18 October 2024

TfNSW reference: WST24/00335/001 | SF2024/171277
Your reference: SSD-48160216| PAE-75538717

SSD-48160216 - Environmental Impact Statement – Maison Dieu Solar Farm – Request for additional information

ROUTE 1 - EX BOTANY

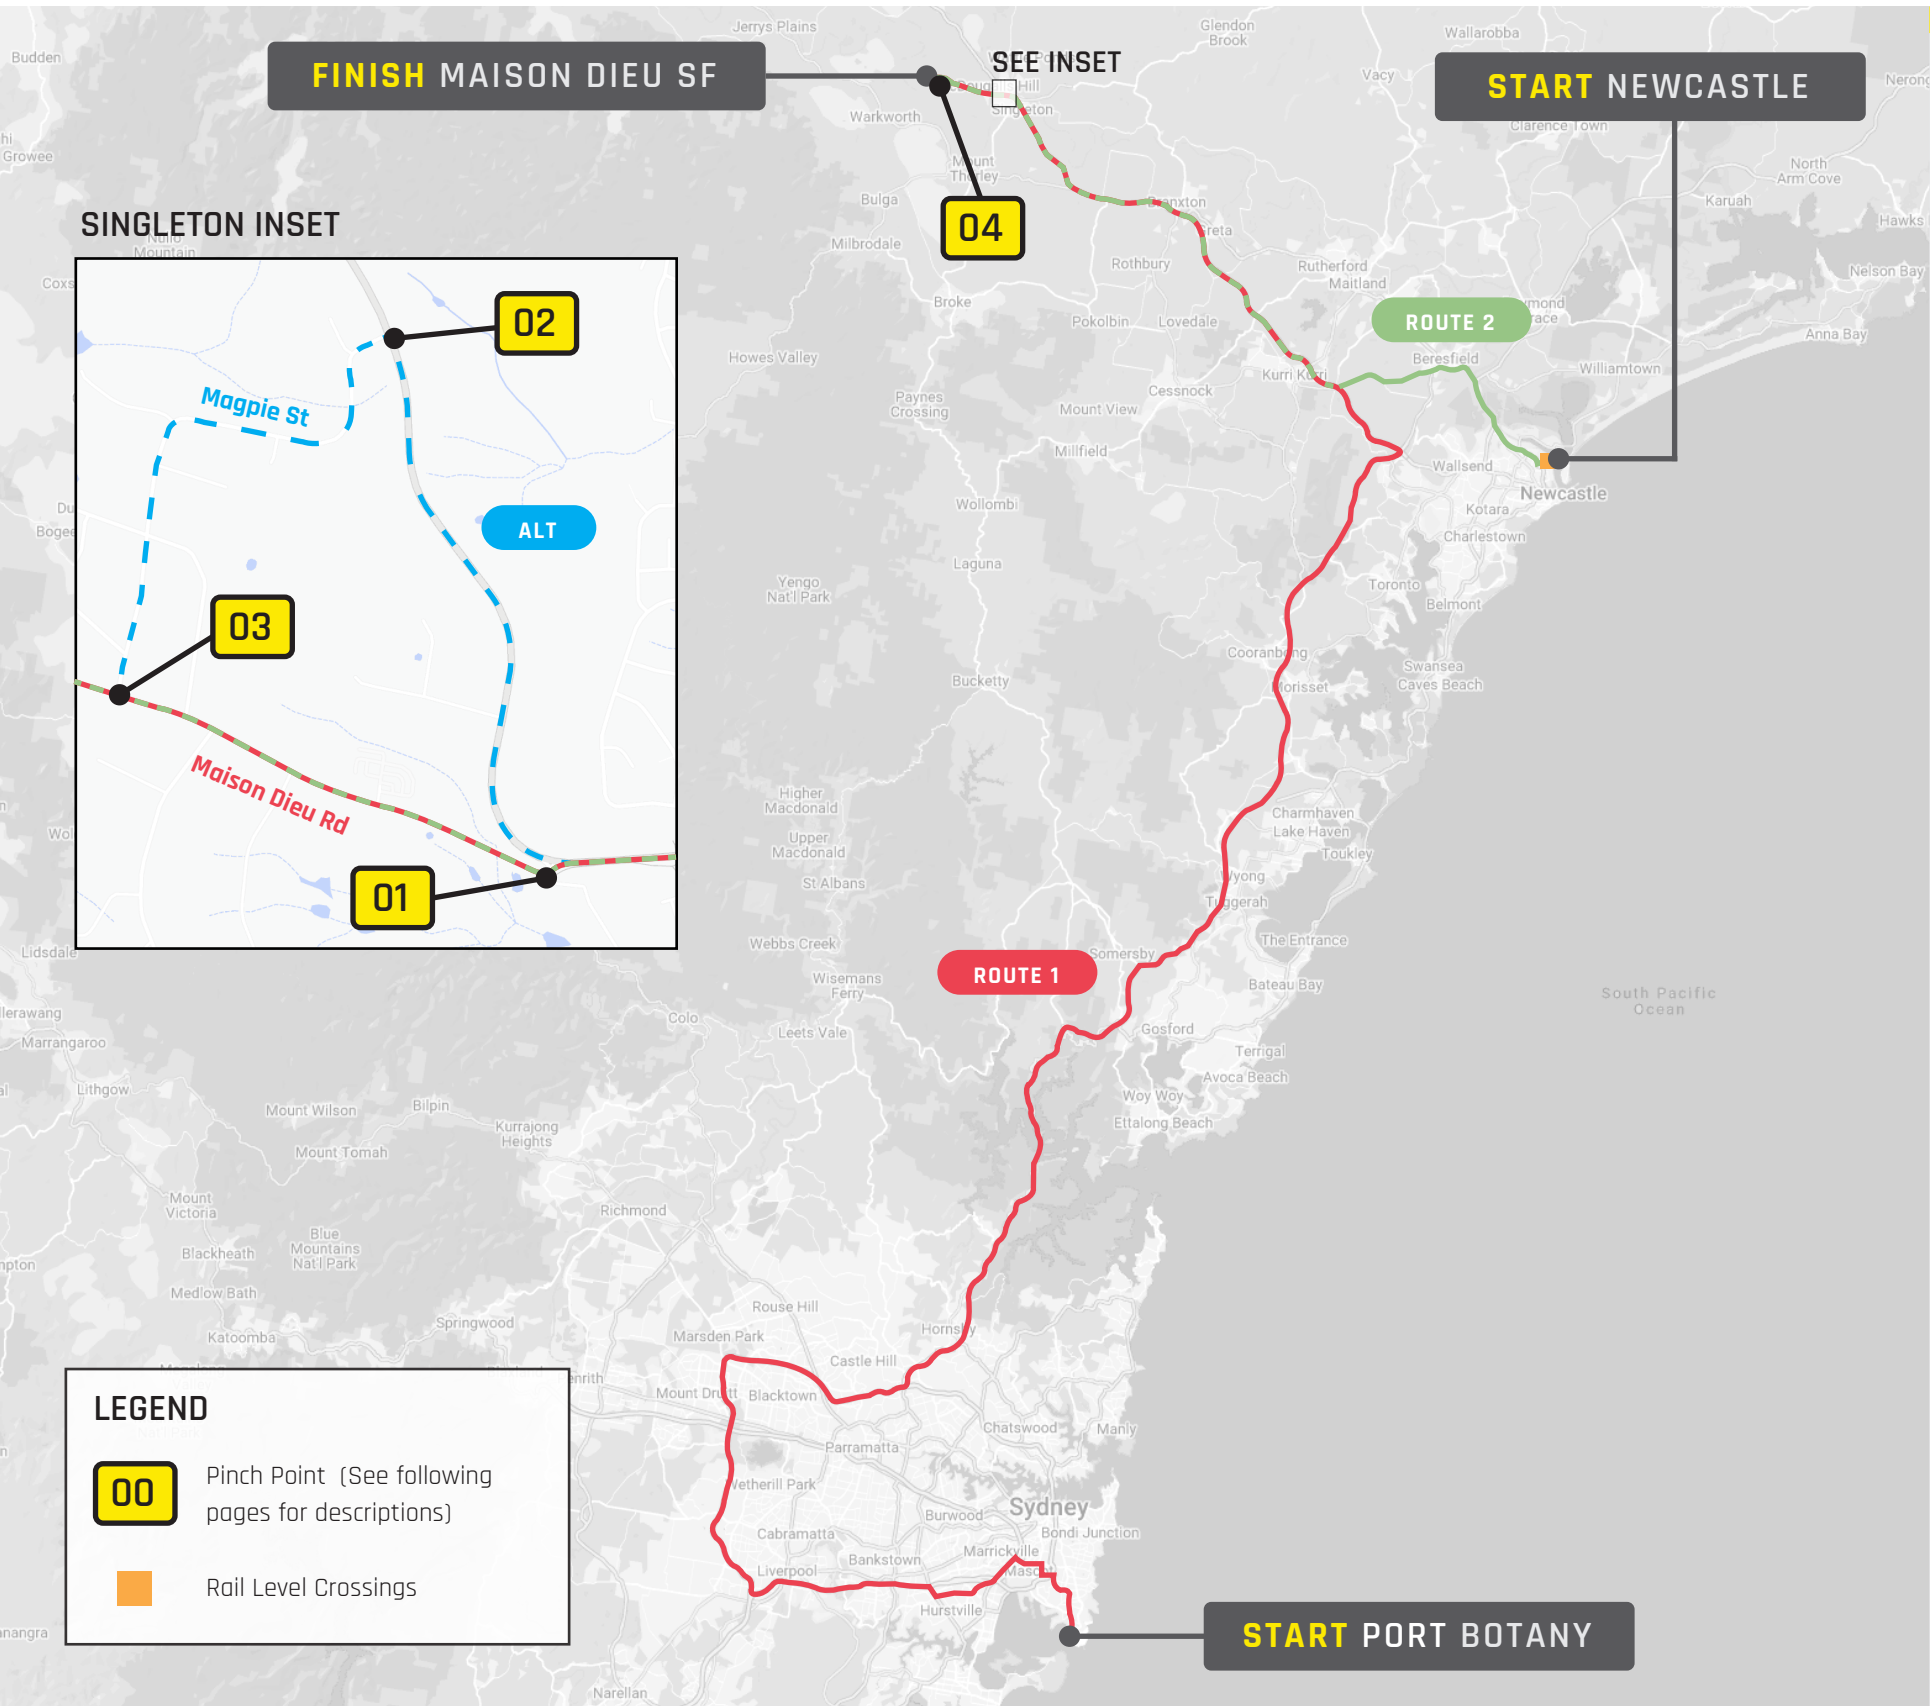
- a. The port or point of origin must be for the entire route to the project access. Confirm if both Port Botany and Port of Newcastle will be required for the high-risk OSOM movements.
- b. Provide the dimensions and weight of the high-risk OSOM vehicles, loads, widths, lengths, class and vehicle configurations. Inclusive of laden dimensions and weights.
- c. Assessment of the impacts vertically and horizontally (inclusive of swept paths analysis) of the high-risk OSOM movement in relation to (not limited to) rail crossings, bridges, intersections, developments, hazards, vegetation, bridges, culverts, medians, intersection treatments, lights, traffic signals, barriers, signage etc treatments and any identified hazards, including each at-risk road structure i.e bridges, traffic signals, signage, major and minor culverts.

Note: the vertical clearances for the Port Botany route are required to be assessed as a part of the update high-risk OSOM route assessment and inclusion of consultation with Northconnex tunnel operator (if applicable to the revised high-risk OSOM route assessment).

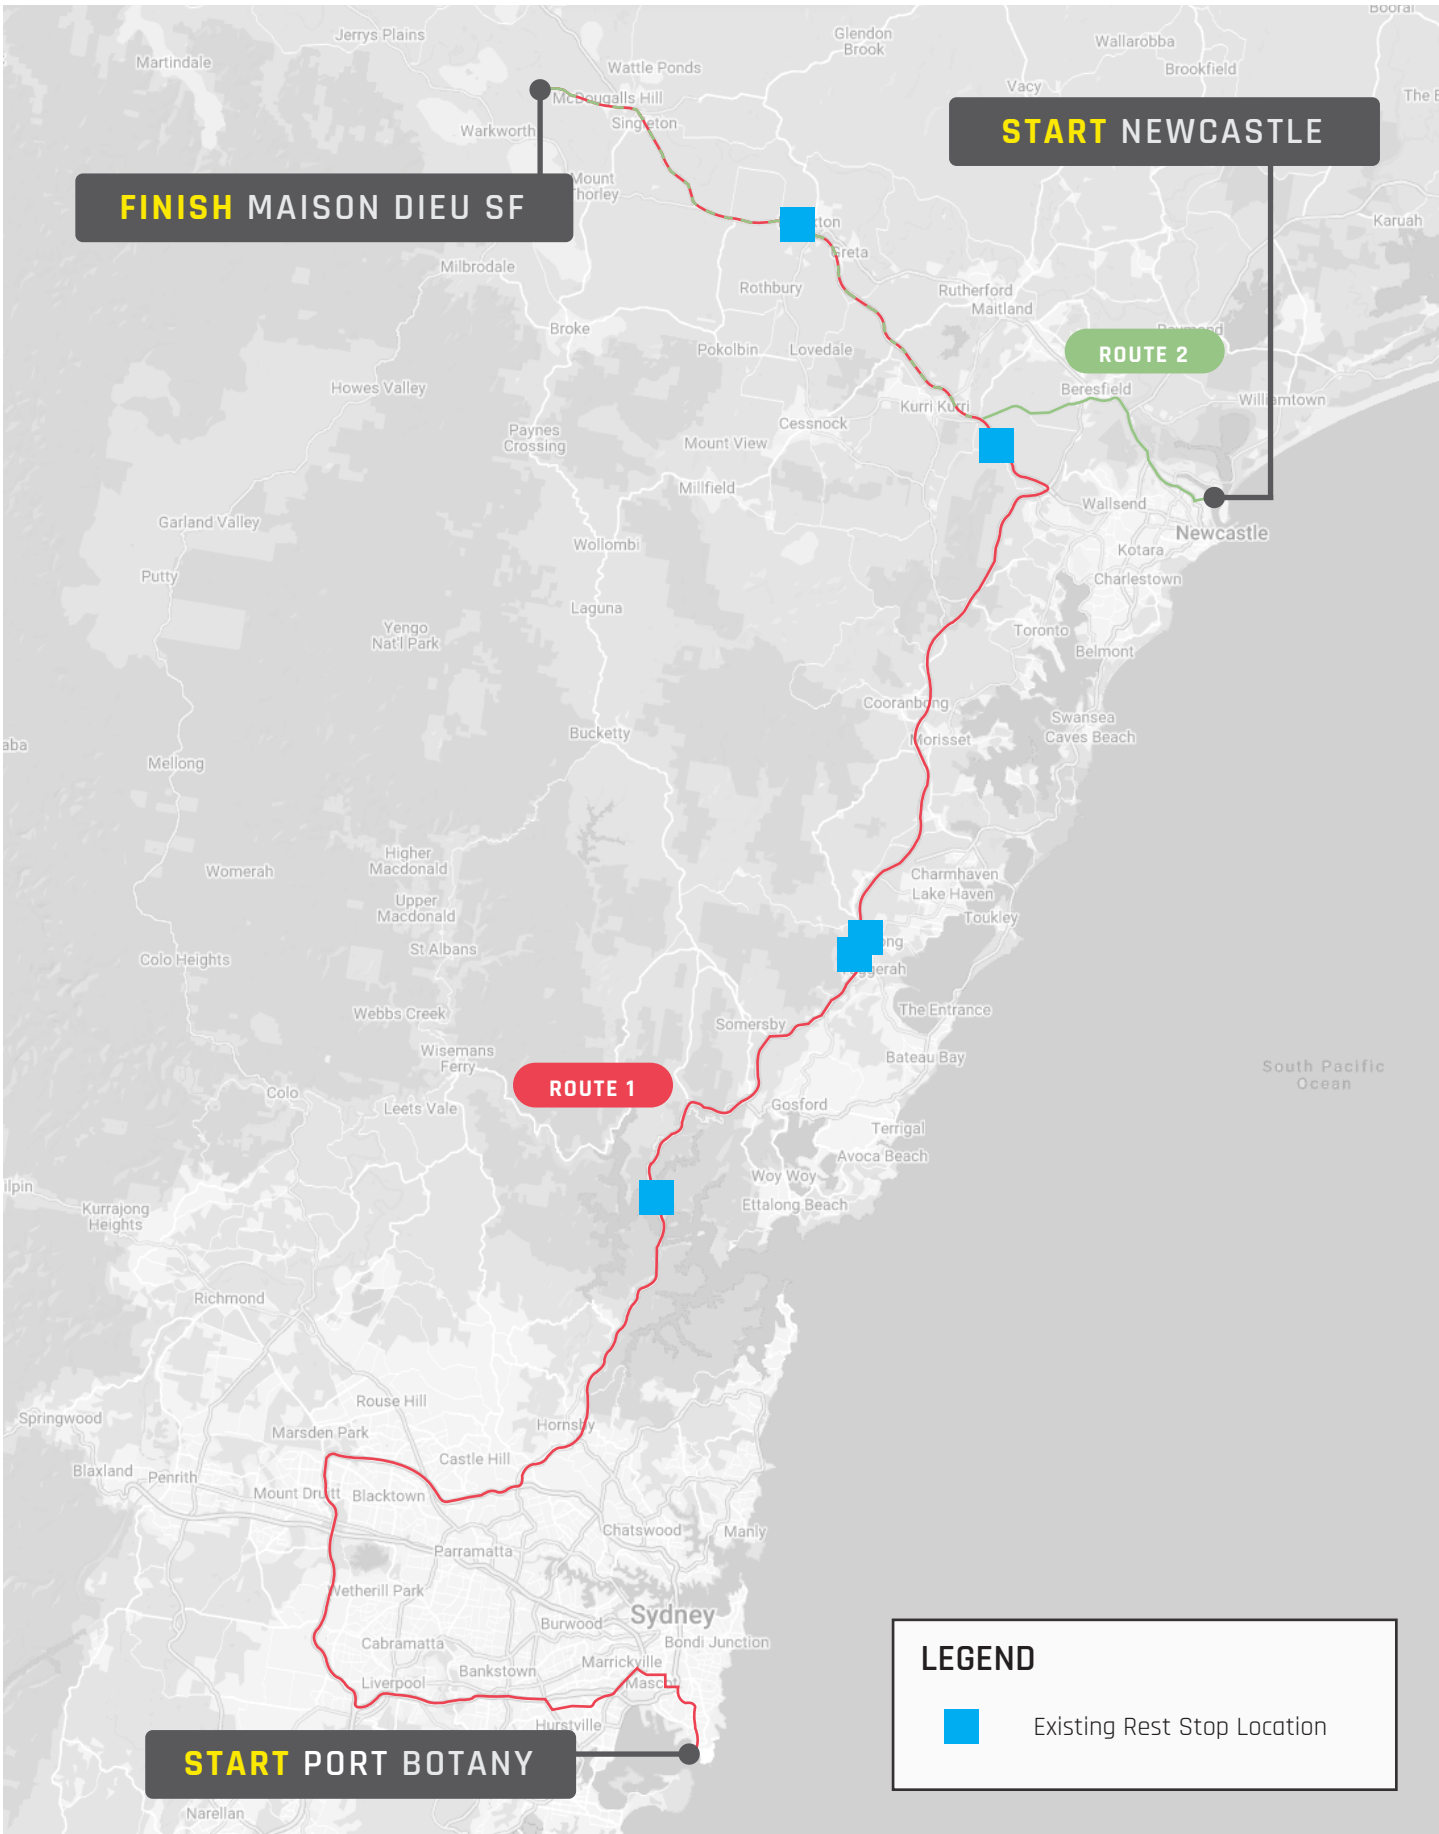
The high-risk OSOM route assessment has not been prepared for a high-risk OSOM movement as the switch room represented in the route assessment is not classed as a high risk OSOM movement (see TfNSW definition of high-risk OSOM). The applicant is to revise the route assessment to align with the weight and dimensions of the largest high risk OSOM (i.e transformer deliveries) and must reassess the following:

LEFT TURN
New England Hwy &
Maison Dieu Rd

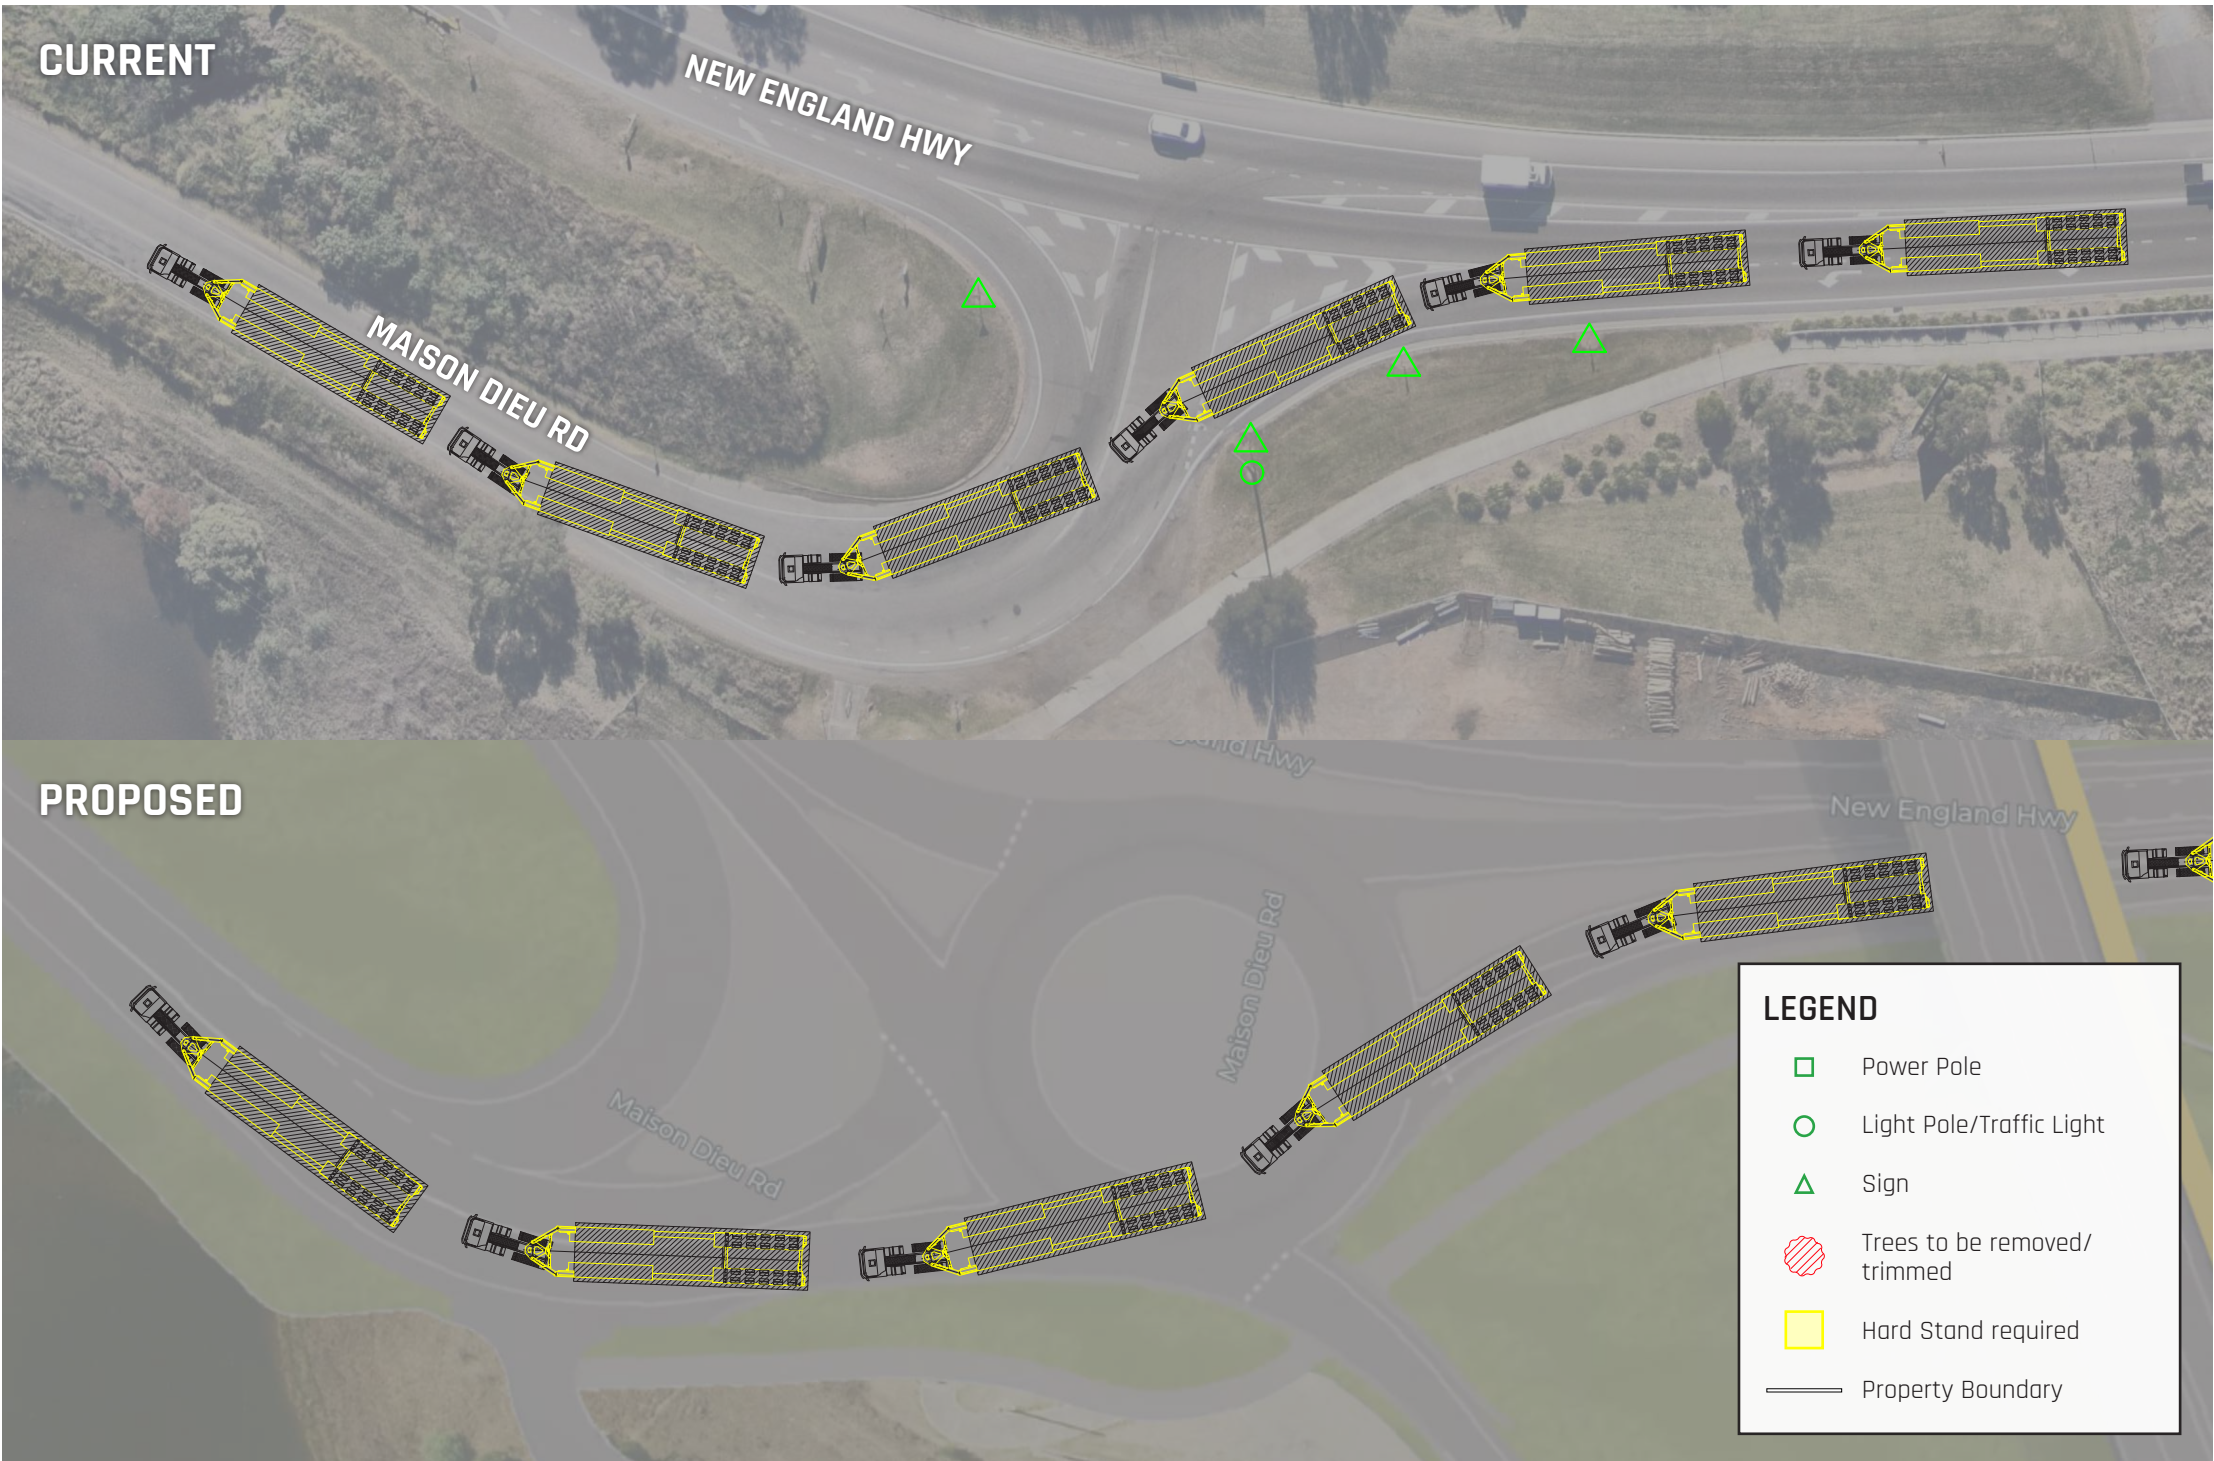
Clarification on how the prohibition and project traffic impacts for each intersection Magpie Street / New England Highway and Maison Dieu Road/New England Highway. The TIA currently identifies that the project traffic will turn left at the Maison Dieu Road/New England Highway and turn right from Magpie Street onto the New England Highway. High level traffic mitigation measures to enforce the proposed turning movements from and onto the New England Highway are to be identified within the revised TIA.

- a. During construction of the bypass:
 - Access to Maison Dieu Road will be closed from Gowrie Gates.
 - The main alignment is not yet open to traffic and other road closures for the bypass may affect the solar farm.
- b. Post construction design:
 - A roundabout will be constructed at the New England Highway / Maison Dieu Road connection.
 - A new connection built to the intersection of Magpie Road.
 - An underpass will be built on the approach to the roundabout from the existing New England Highway.
